Department of Planning, Industry & Environment
GPO Box 39
Sydney NSW 2001

Application No: SSD-10831778

Re: Randwick City Council submission on the State Significant Development SSD-10831778 – Sydney Children’s Hospital Stage 1 and Children’s Comprehensive Campus Centre (SSD-10831778)

4 PROPOSED SHADOWS - JUNE 21 - 9AM
1:1500

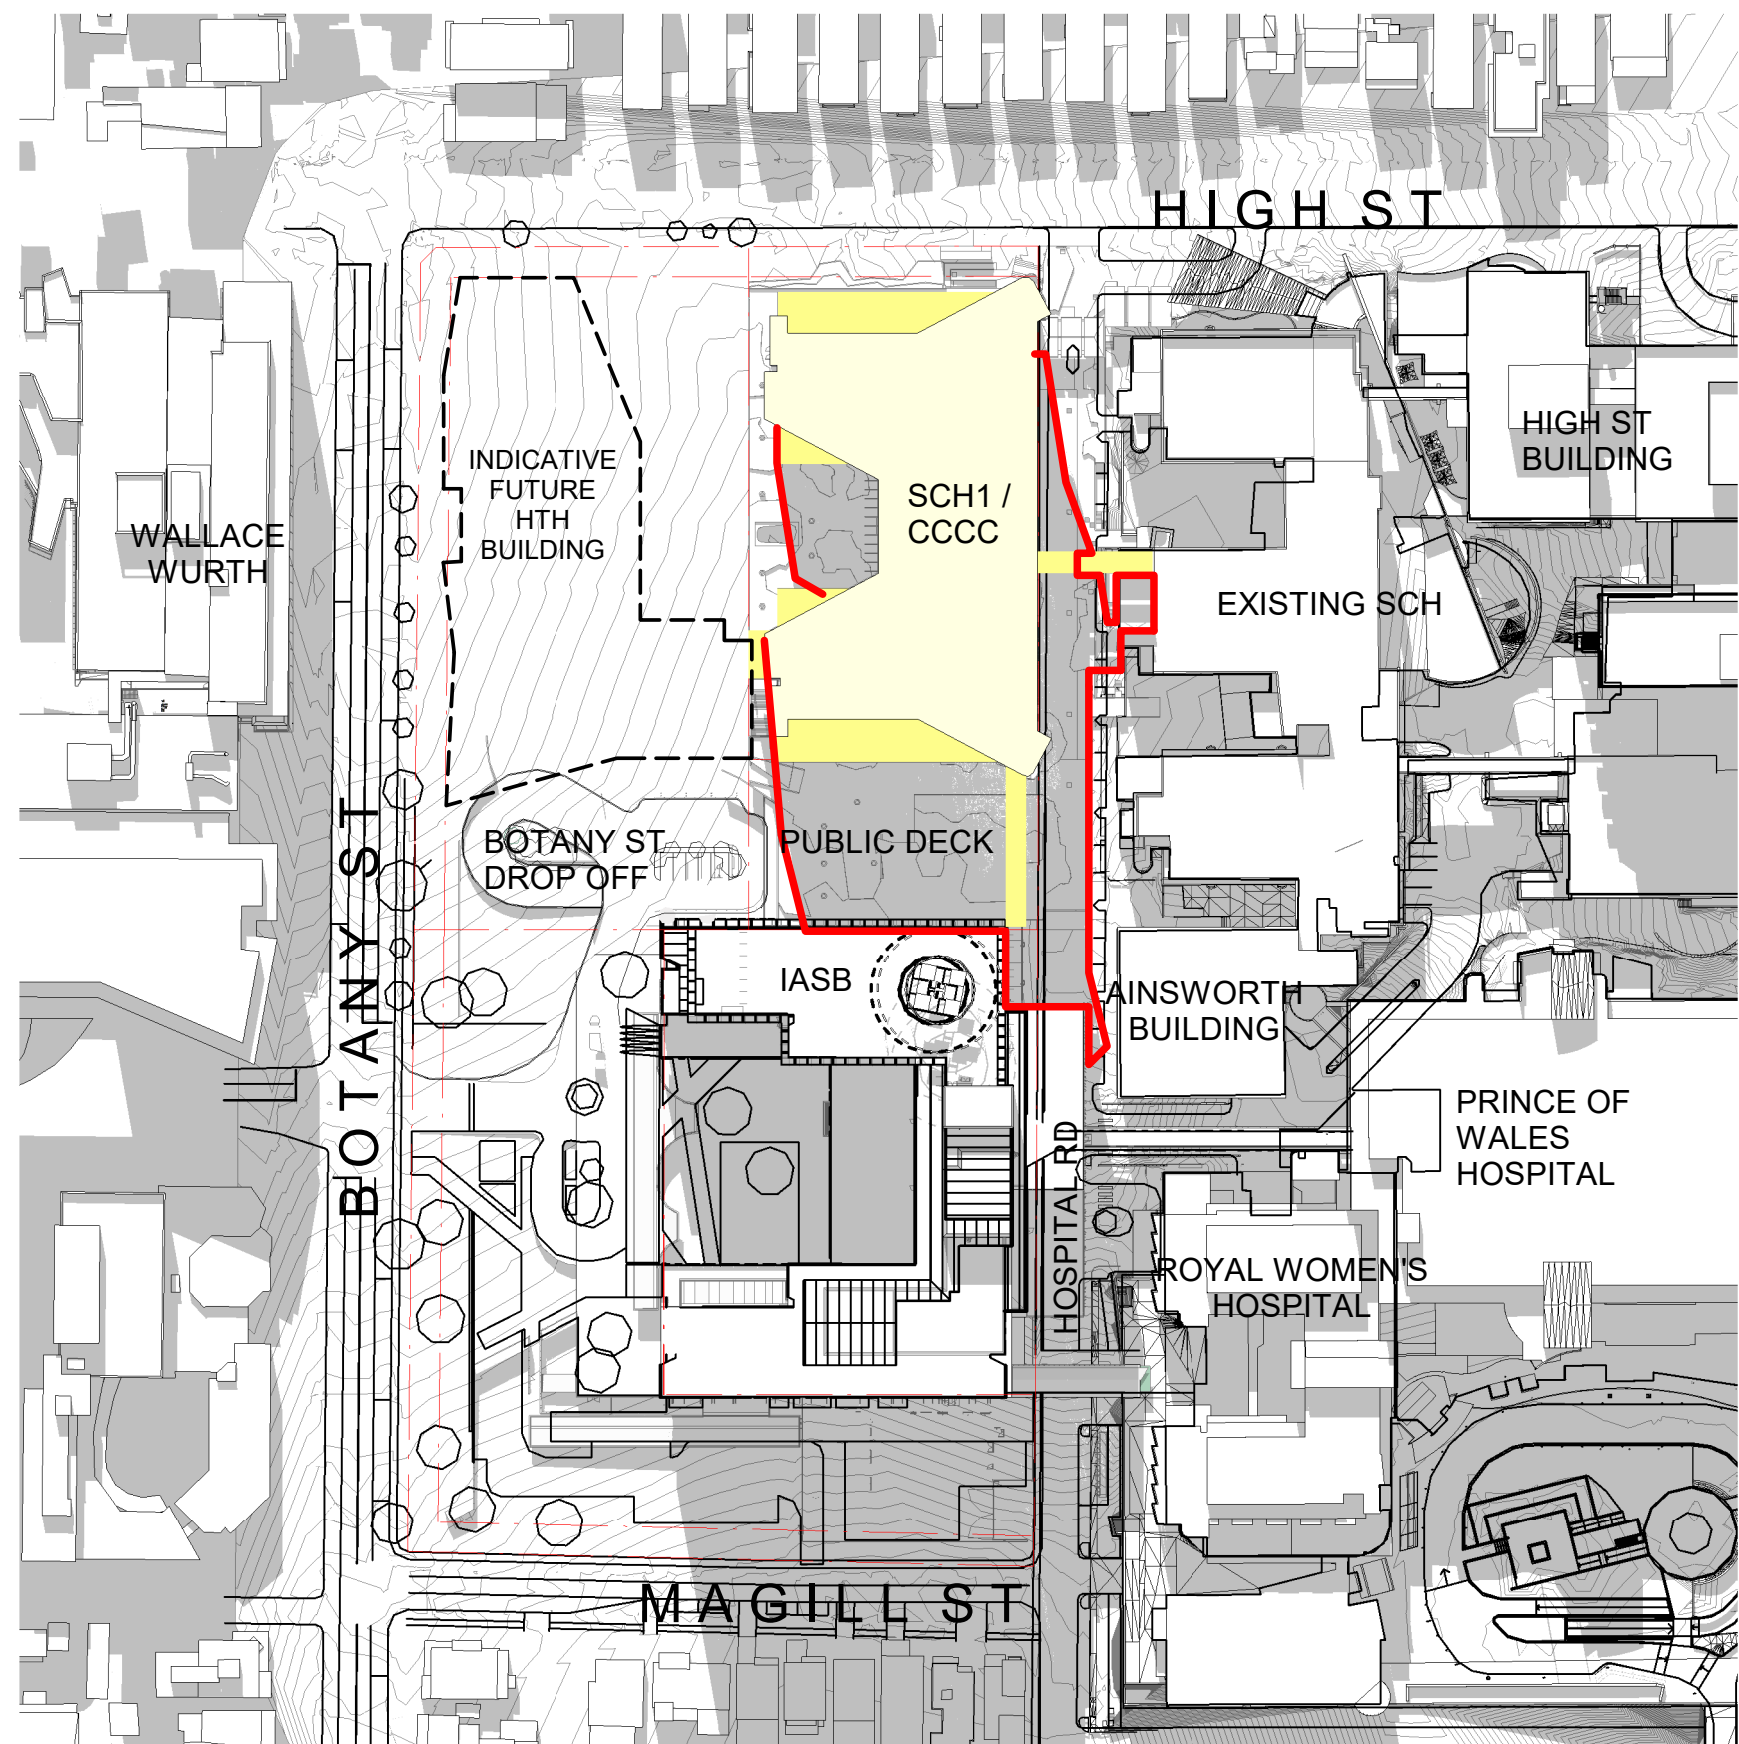
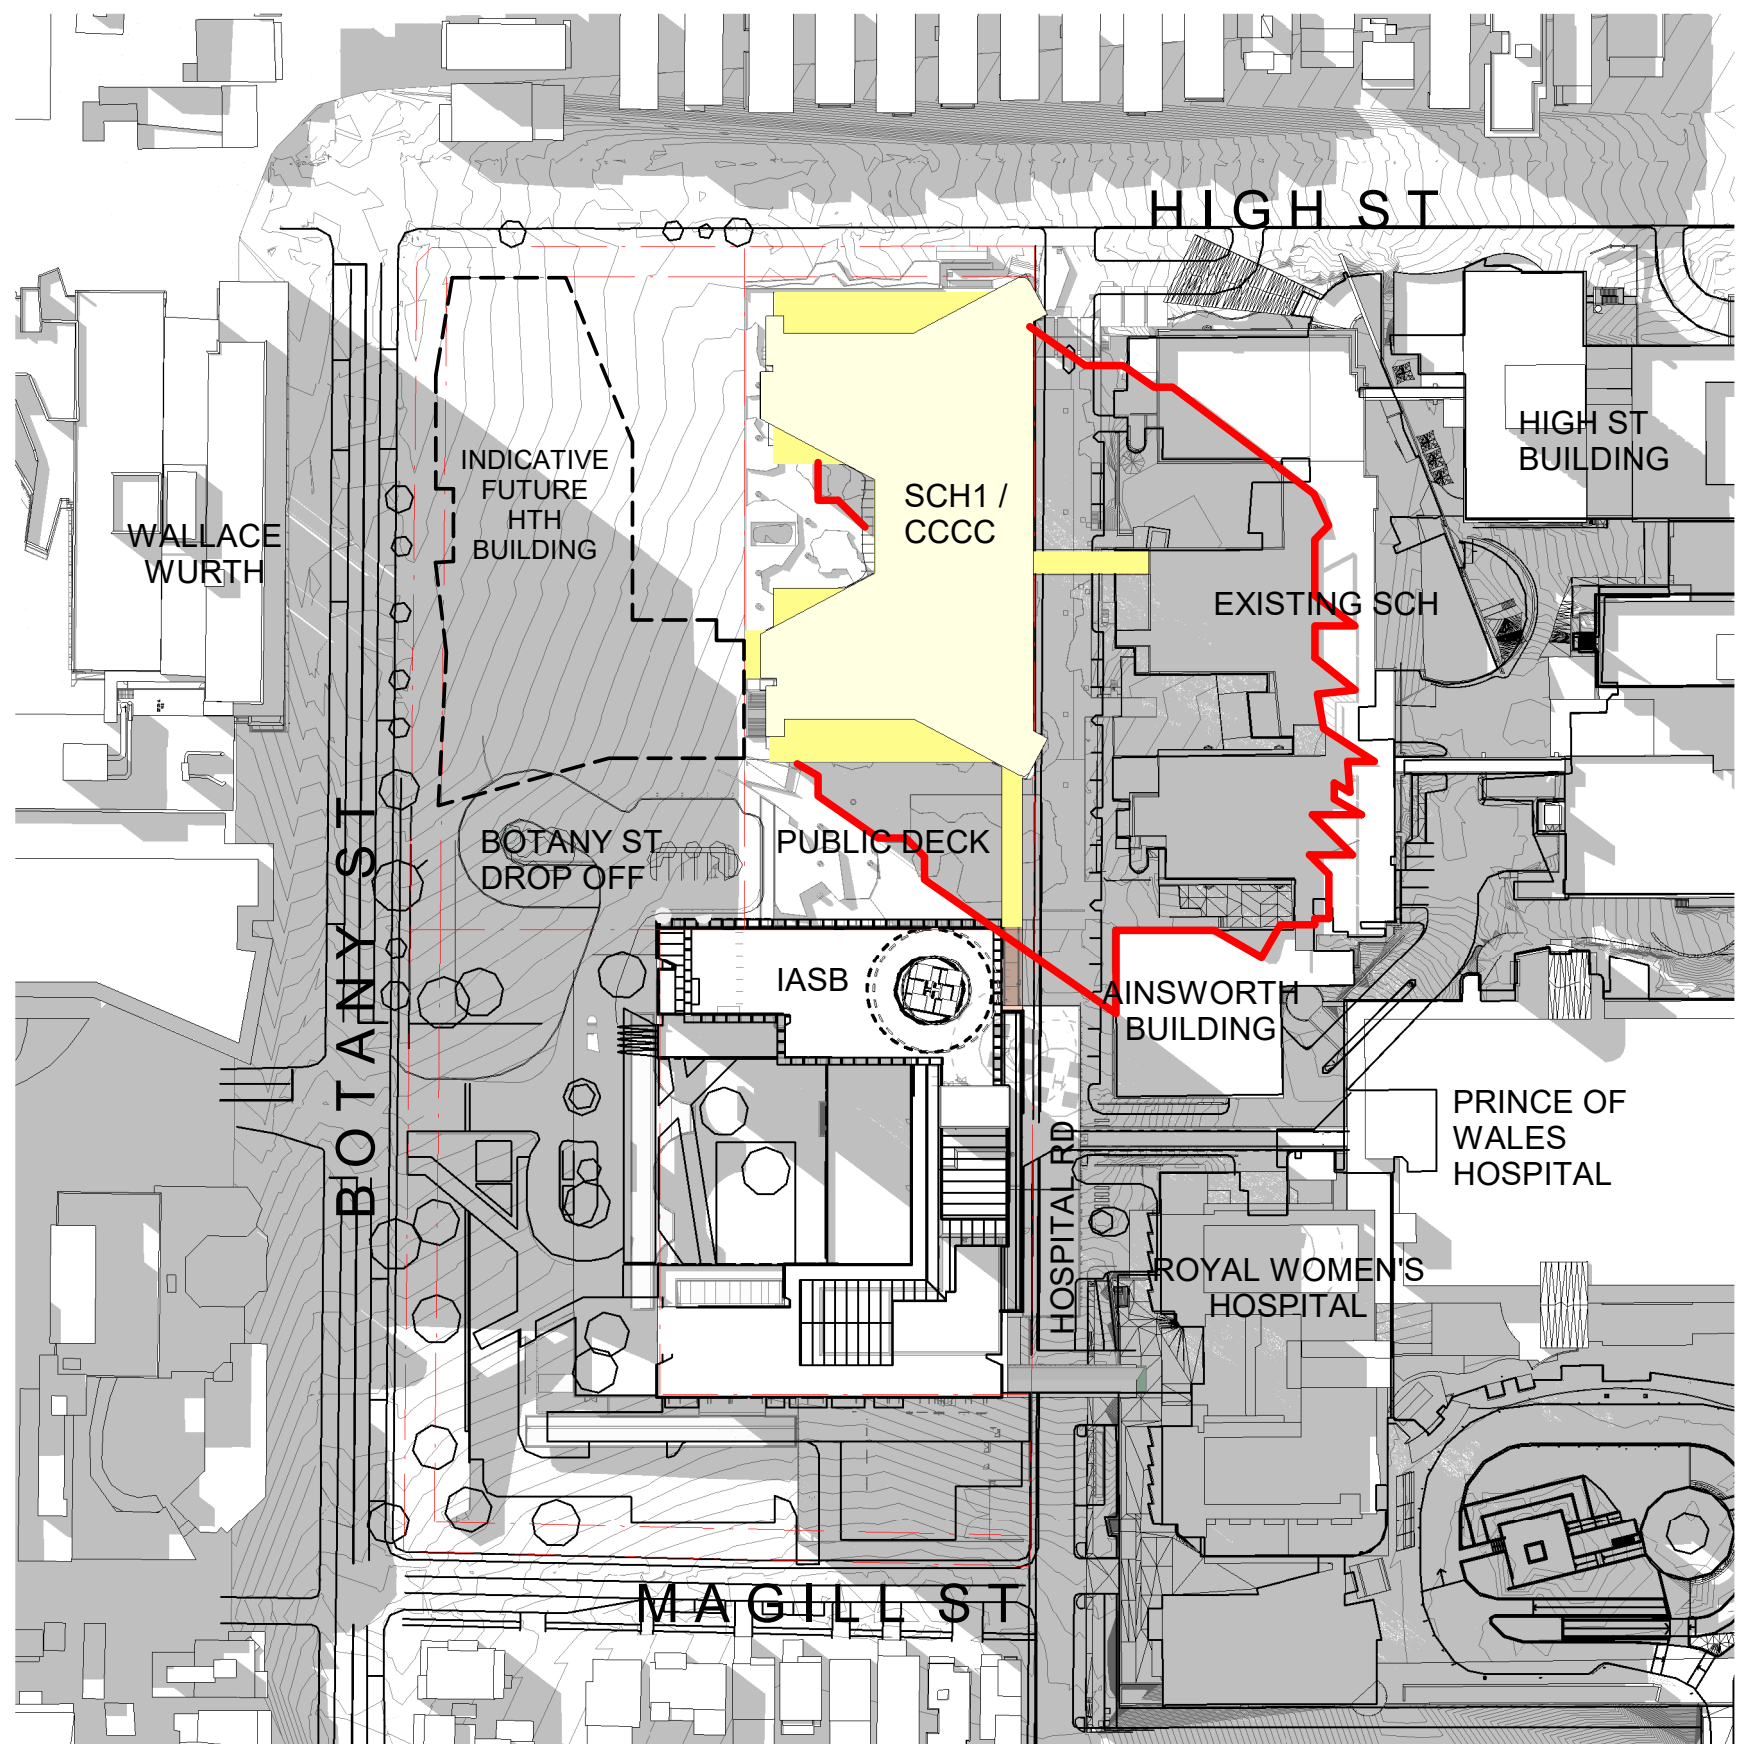
28. The proposed building will significantly overshadow the proposed children's play area through most of the year and particularly during the winter months, resulting in an inappropriate location for a children's play area. A location that receives sunshine, with a northern aspect would be preferable. Locating the play area to the north of the building, within sight of the proposed café, would provide a safer and more welcoming location. Alternatively, a north facing play area on an upper level terrace or roof of the building could be considered.

29. The north leg of the building, as proposed, blocks mid-morning sunshine from reaching the plaza. Reshaping and or increasing the height of the undercroft of the north west corner of the building should be explored to improve solar access to the plaza in the mid-morning.
